From: Steven Shaw [REDACTED]
Sent: 20 April 2018 11:28
To: Claire Potts
Cc: Stephen Gee
Subject: RE: A/23/15/OUT and A/11/17/OUT

Access

Title
HIGHWAY ACCESS PLAN

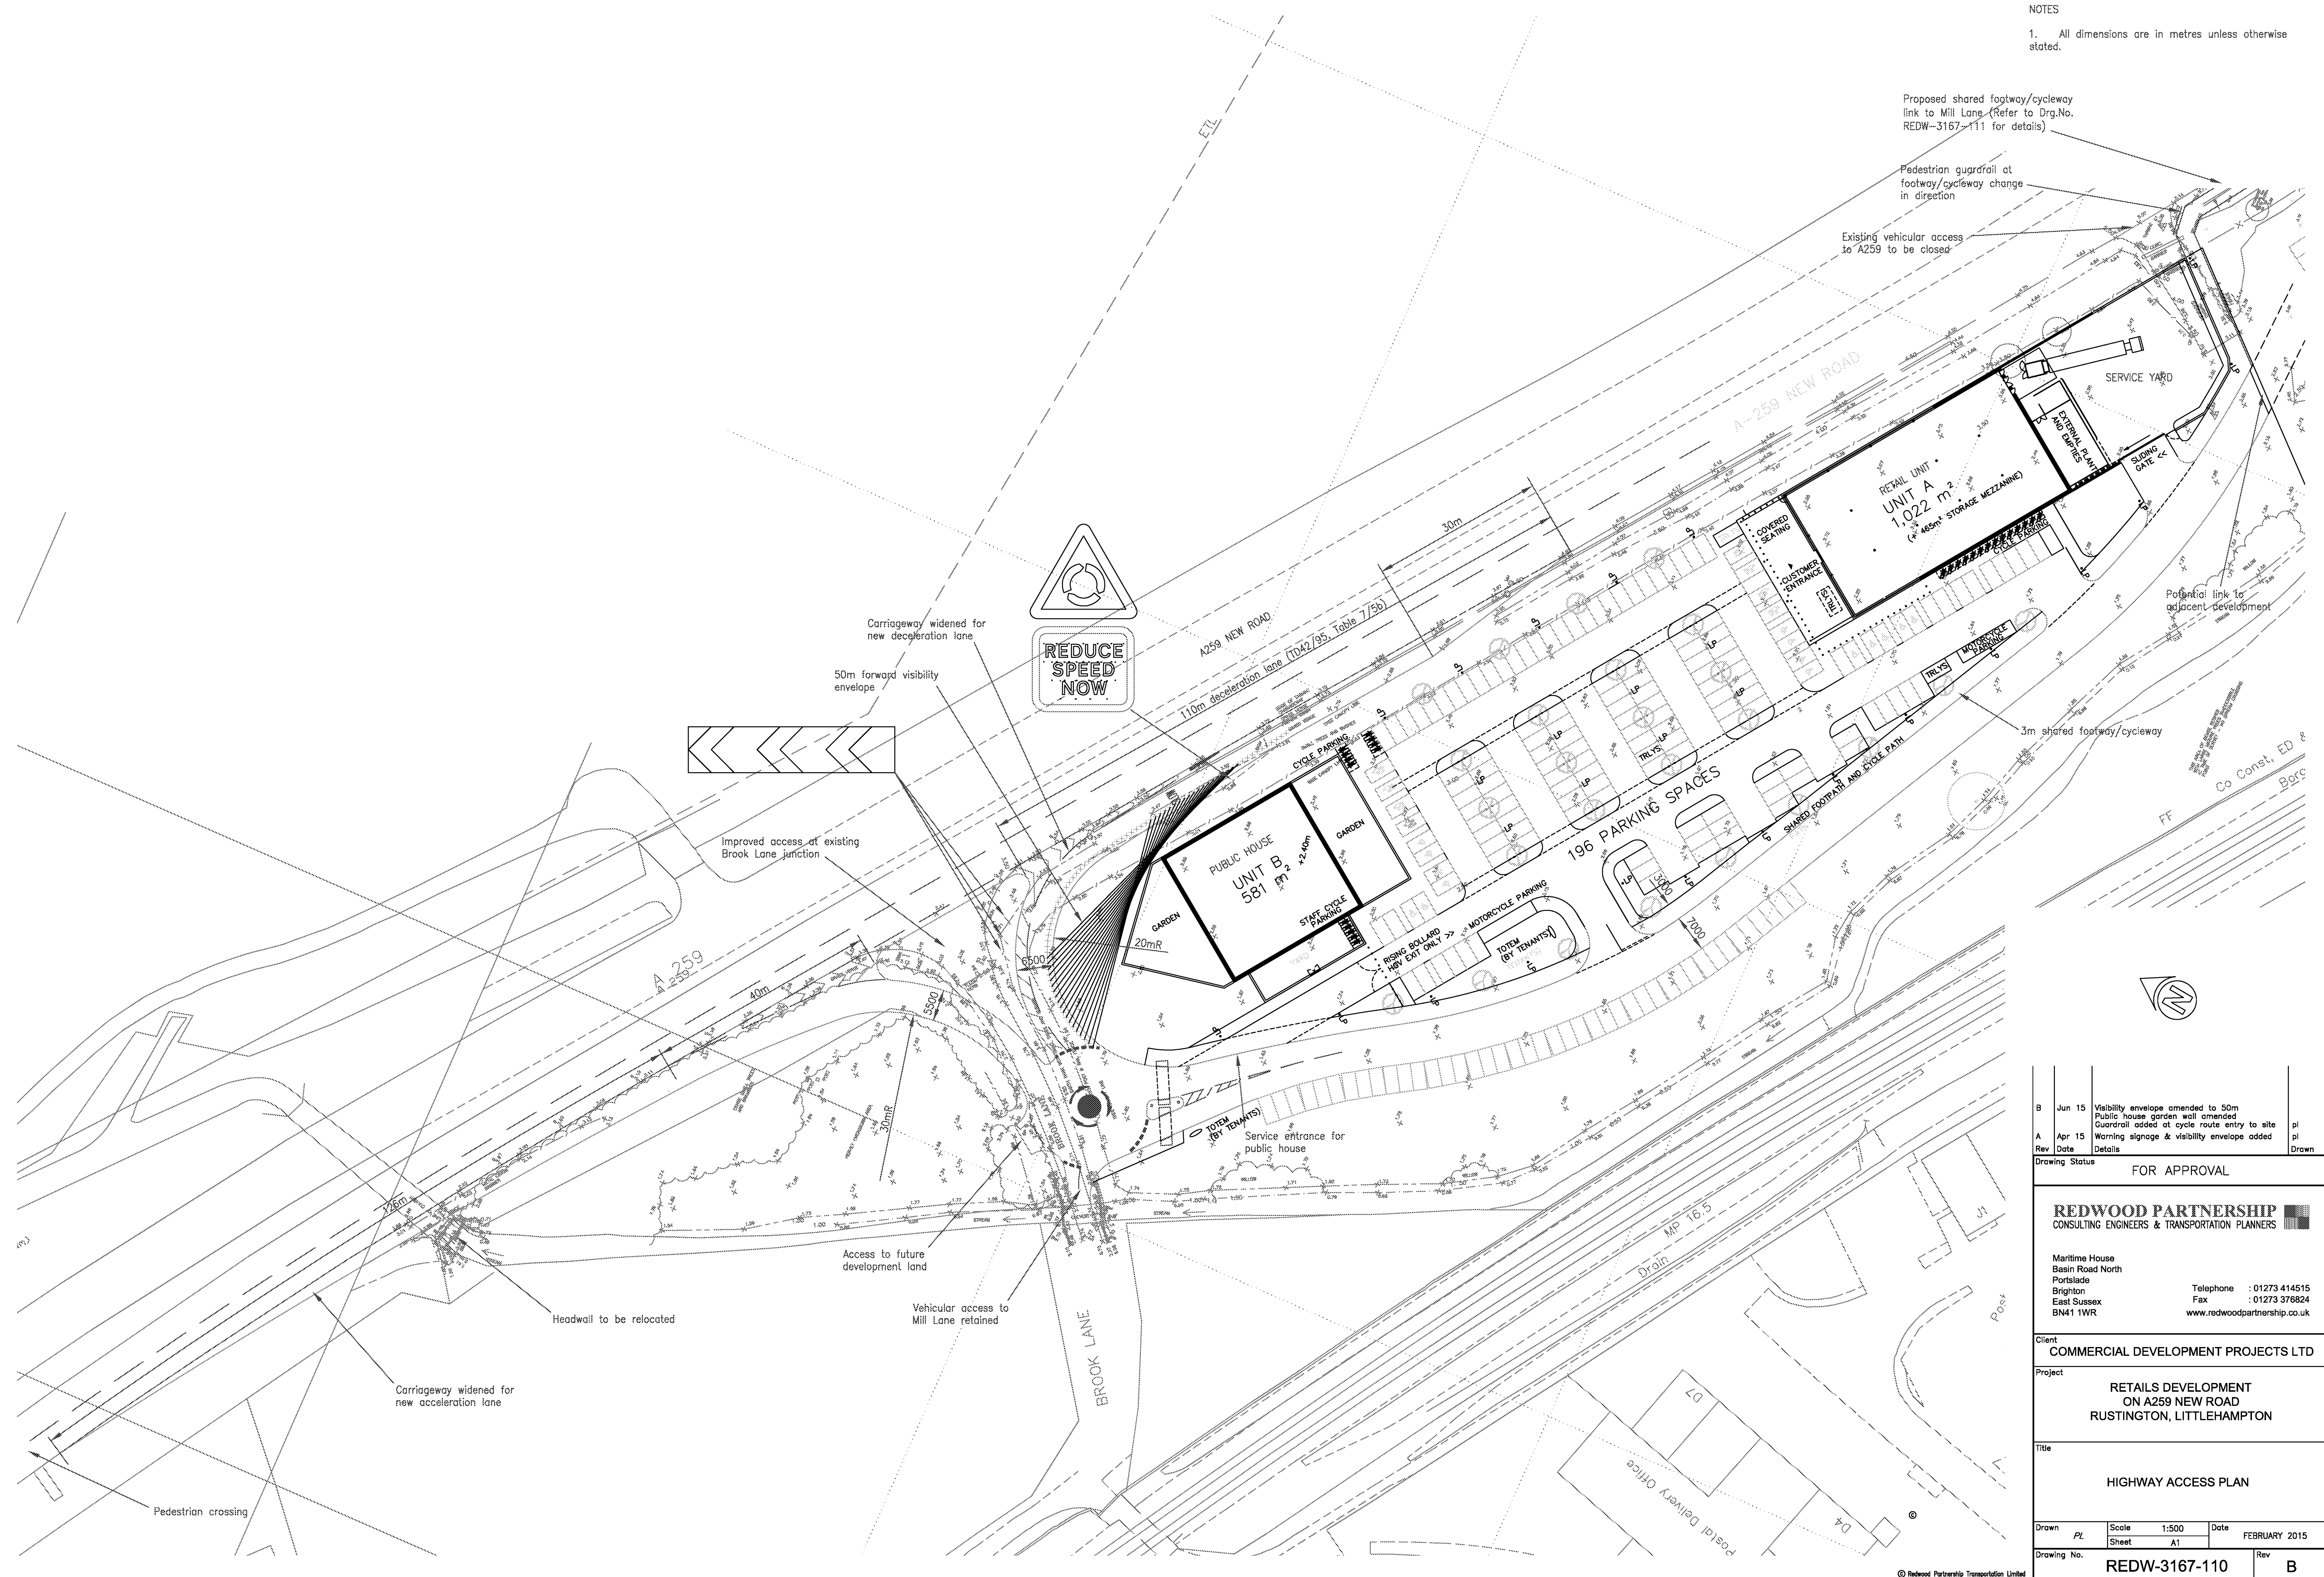
The applicant for planning applications A/11/17/OUT and A/23/15/OUT needs to demonstrate that a safe and suitable access can be provided to both their site and does not preclude access to the committed development site. At the moment they have not done this and the proposed access arrangements from both sites are conflicting. A revised drawing needs to be submitted that demonstrates how access can be provided to their site and the

adjacent. Drawing number REDW-3167-131 (Highway Access Plan) should be updated to include an overlay of the adjacent site and demonstrate how a safe and appropriate access could be provided to the adjacent site.
